KIRKLEES METROPOLITAN COUNCIL INVESTMENT & REGENERATION SERVICE

DELEGATED DECISION TO DETERMINE APPLICATIONS FOR LISTED BUILDING CONSENT

Reference No:	2026/65/91370/W
Site Address:	George Hotel, St George's Square, Huddersfield, HD1 1JA
Description:	Listed Building Consent for internal works to allow the installation of a temporary staircase (to facilitate construction works in association with the refurbishment and redevelopment of the George Hotel and its coming into operational use to provide 108-bedroom hotel with bar, restaurant, gym, conference facilities and ancillary facilities, approved under previous Listed Building Consent application reference: 2025/91148 and previous planning permission reference: 2025/91147) (Listed Building within a Conservation Area)
Recommending Officer:	Jillian Rann

Application: 2026/91370

2 Level 02 - Haki Stair Demolition Plan  
1 : 100

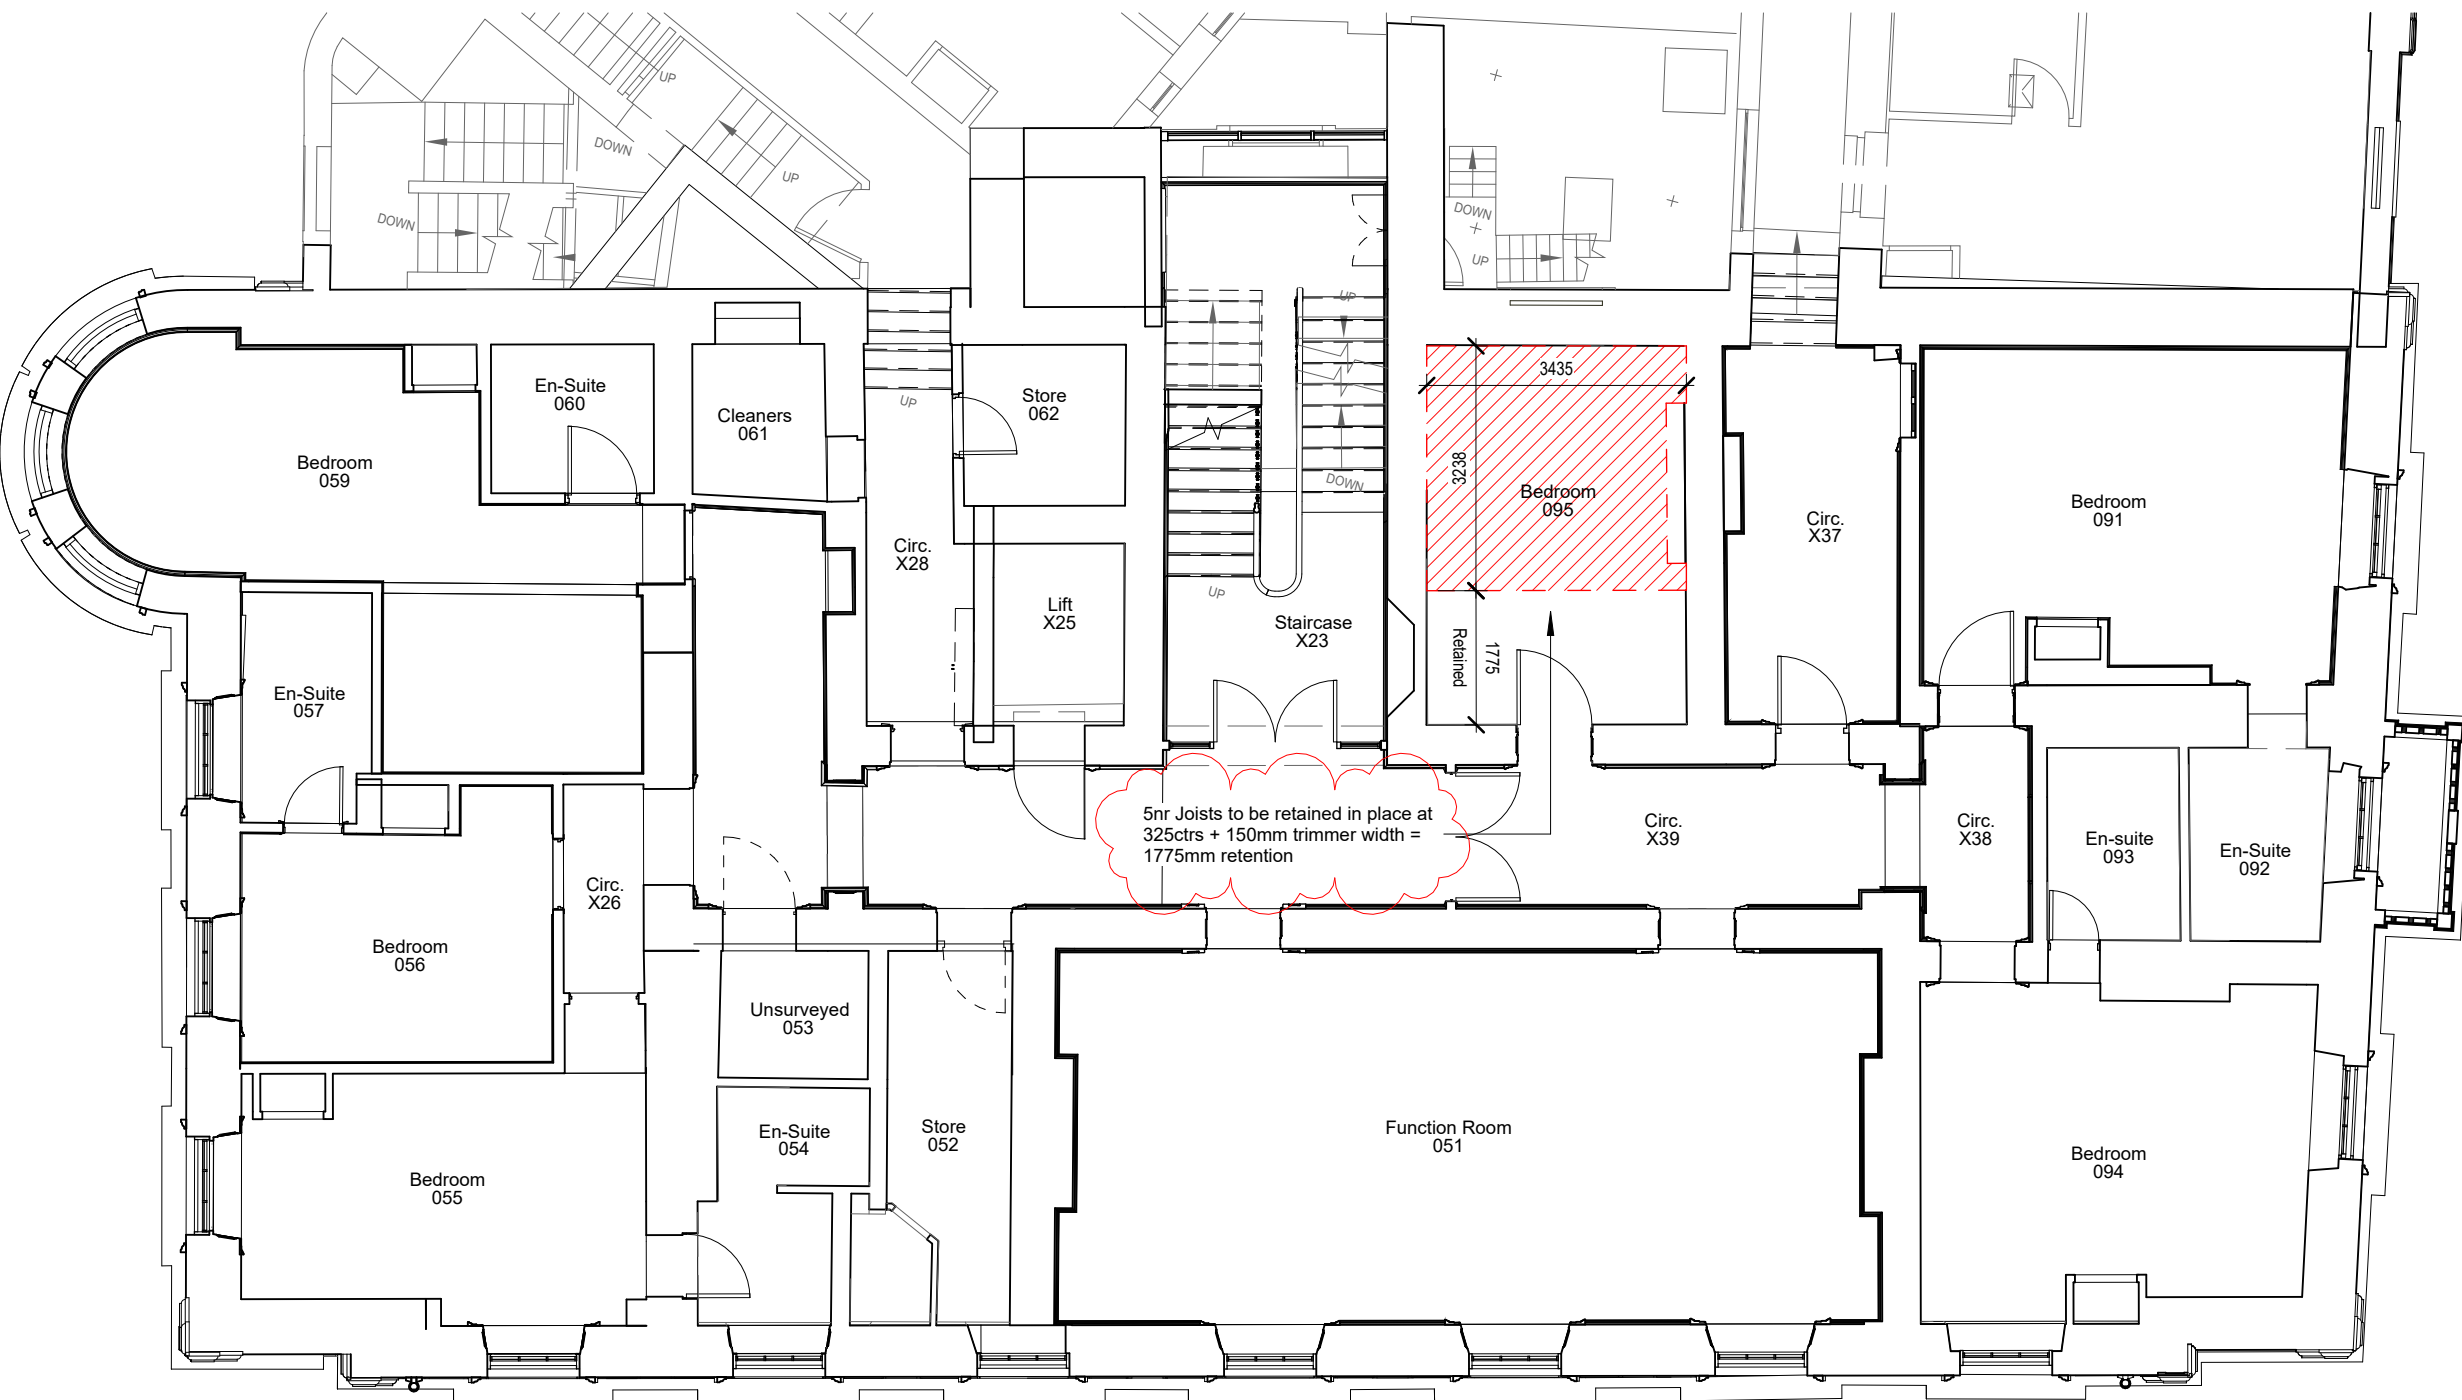
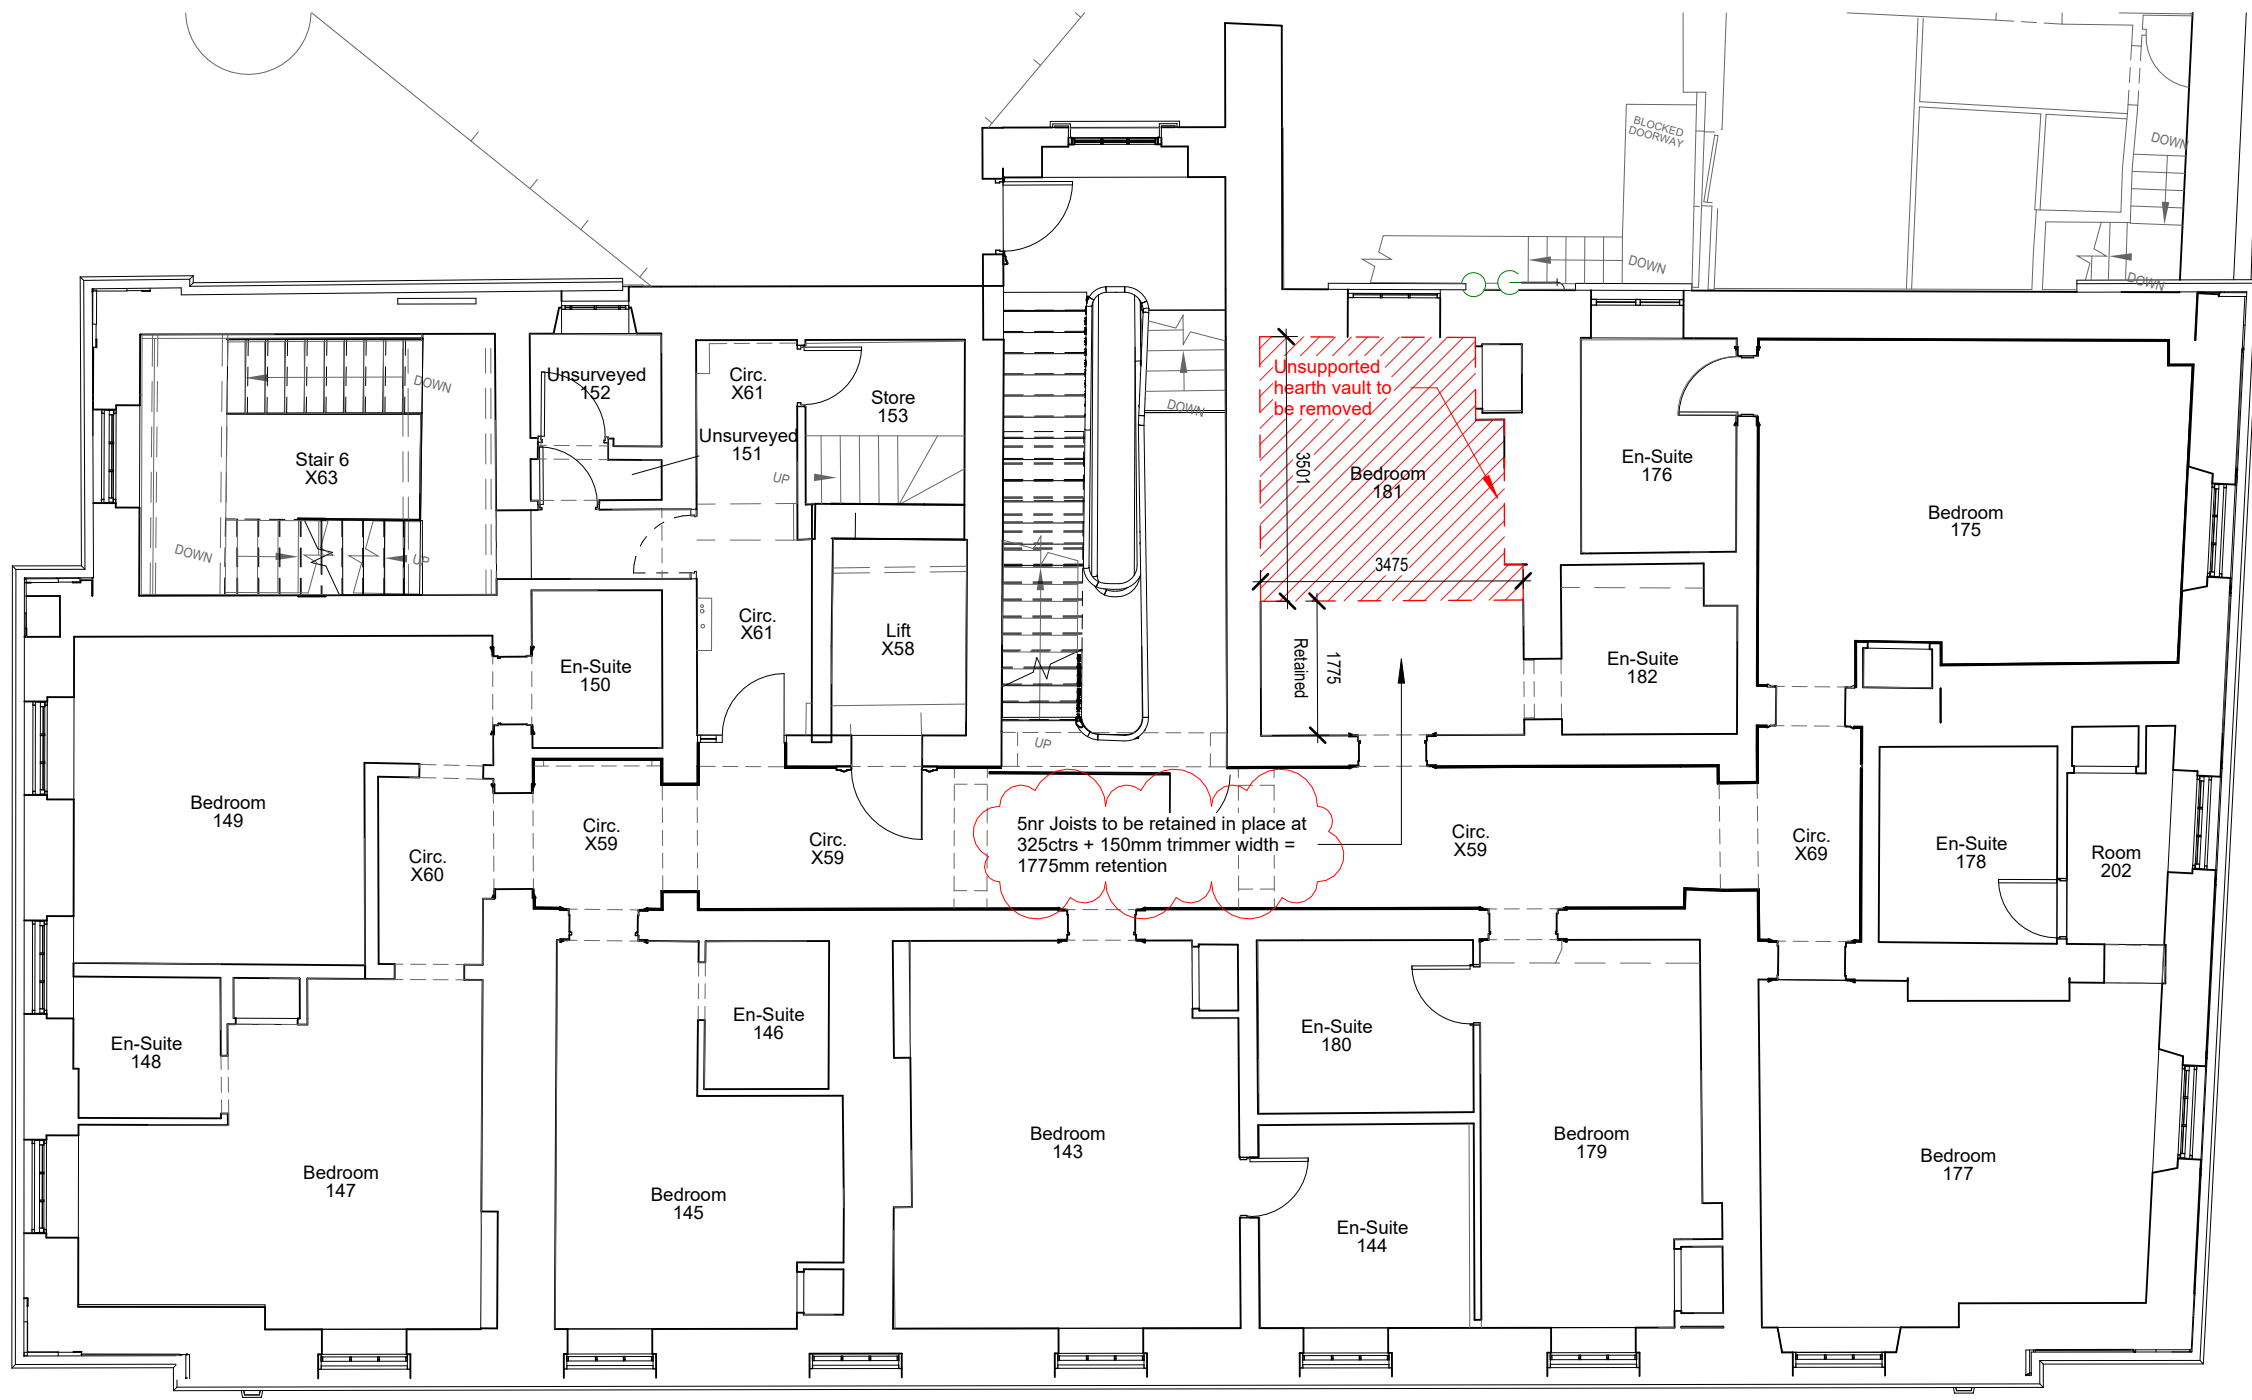
The revised plan now shows the removal of a smaller area of floor/ceiling from several of the relevant rooms than was originally proposed, and states that

several joists are proposed to be retained in place near the entrance to each of those rooms.

Officers raised queries with the applicant about whether the proposed removal of the floors from the relevant rooms would have any implications for the

stability of the historic staircase within the existing building (which adjoins those rooms). Clarification was also sought about whether it was proposed to remove the full extent of the floors/ceilings from those rooms, or only parts of those floors/ceilings.

In response, the applicant has submitted a revised Demolition Plan, which shows the retention of part of the floors/ceilings closest to the entrance to each of those rooms. A 'Wall Stability Statement', prepared by a Structural Engineer, has also been received, which includes a proposal for the HAKI stair to be fixed to both walls to provide lateral restraint. A further updated Wall Stability Statement has subsequently been received, which includes further information about the sequencing of the proposed works, in response to queries from the case officer in that regard.

SK01 – Plan showing floor spans

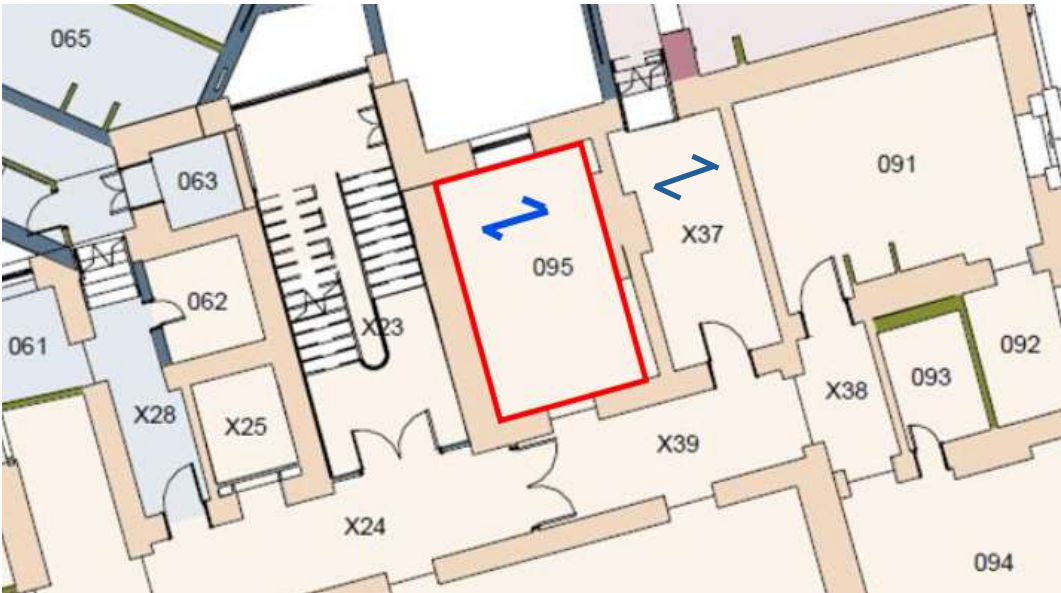
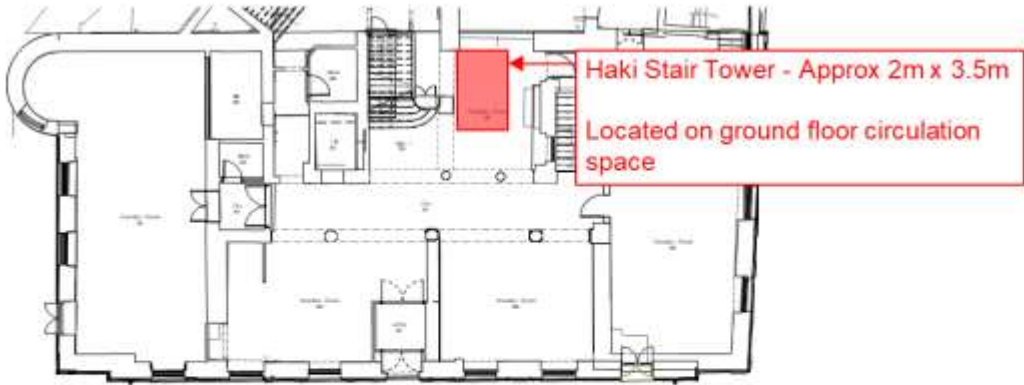
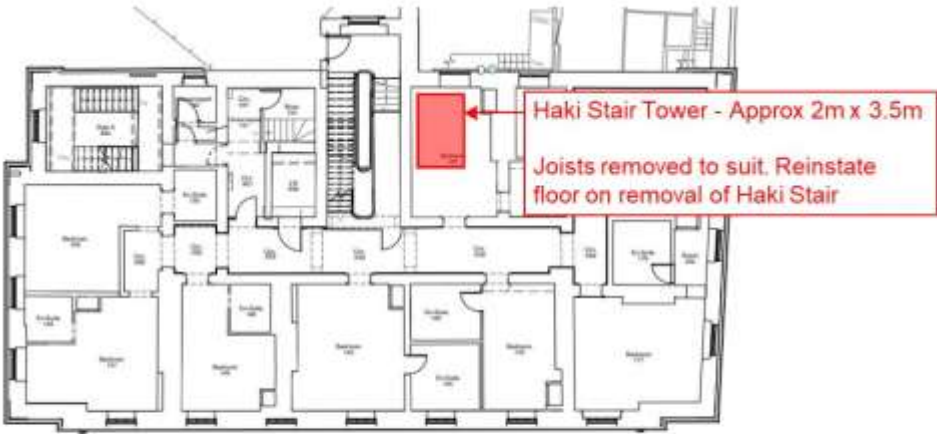
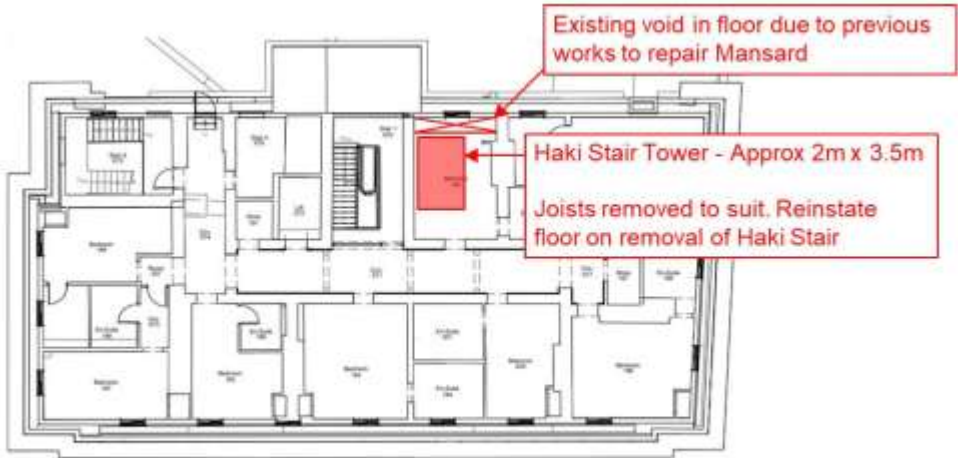
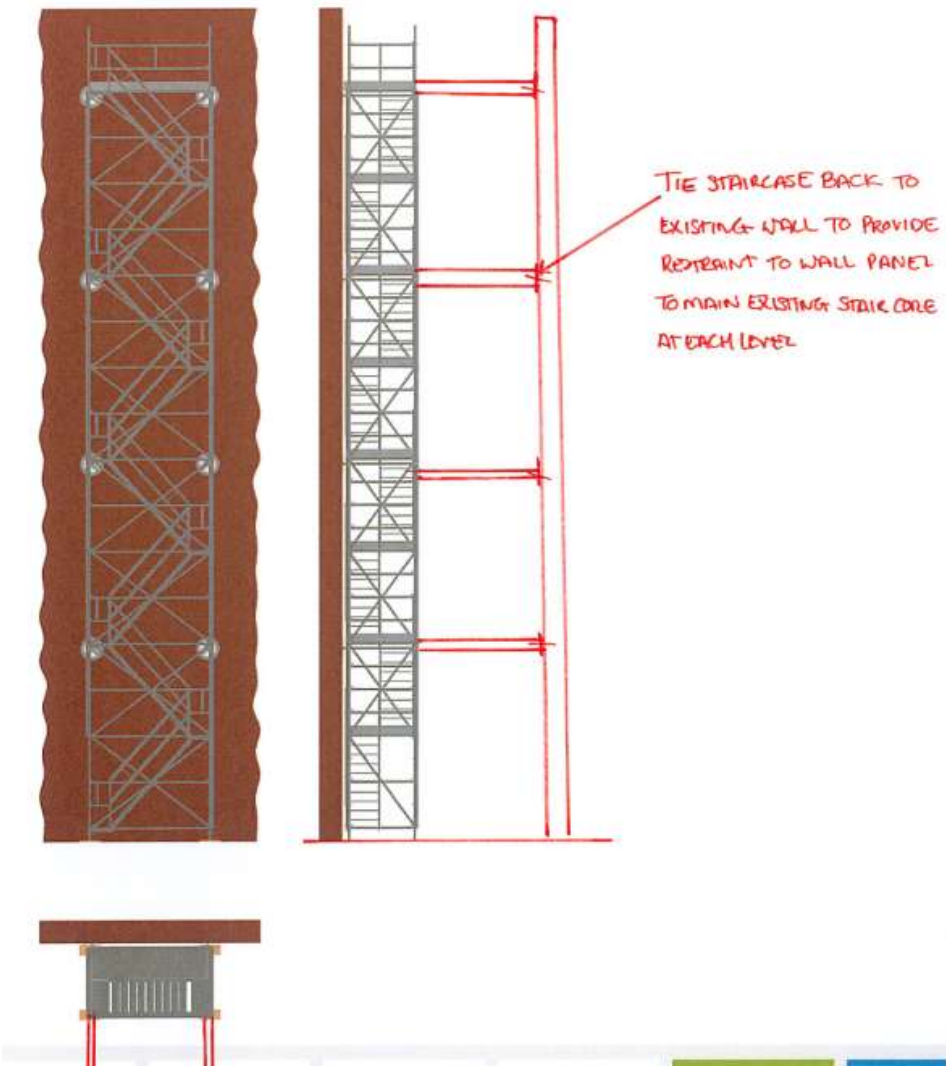
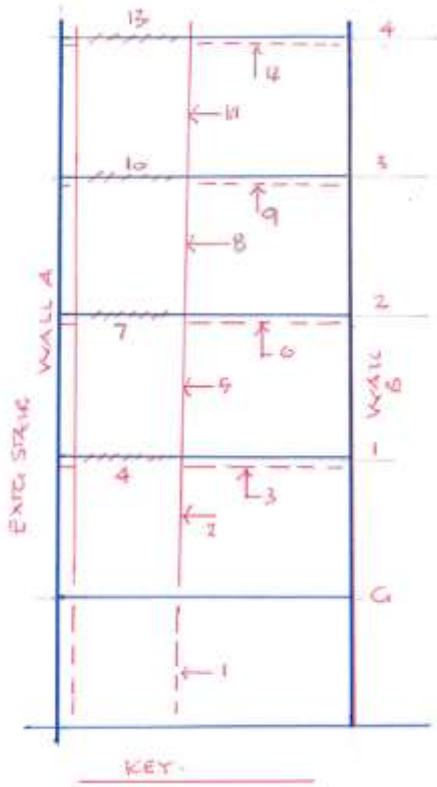
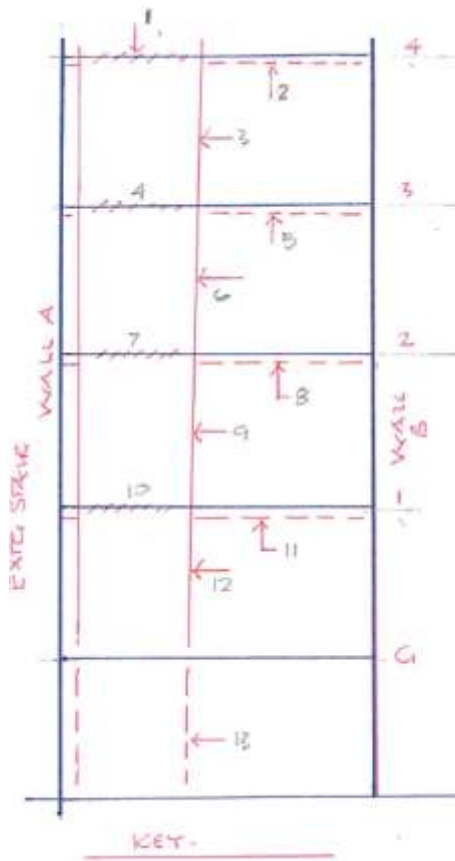
The Wall Stability Statement was provided in response to a query from officers about whether the proposed removal of sections of the floors from these rooms would have any implications for the stability of the historic staircase, which adjoins those rooms. It notes the proposed removal of part of the existing floors, and proposes that the HAKI stair be fixed to both walls to provide 'lateral restraint'. An updated version, providing further information including details of the proposed sequencing of the construction of the temporary staircase relative to the removal of the floors at each level, and its deconstruction relative to the reinstatement of each floor, has subsequently been received, following a request from the case officer for further clarification on this matter. This is discussed further below.

An updated Wall Stability Statement was subsequently received, including further information about the proposed sequencing of works to remove floors and install the temporary staircase, and then to remove the temporary staircase and reinstate the floors. Some further clarification from the agent for the application was also received. In the light of this, the Conservation Officer has confirmed that the details are acceptable.
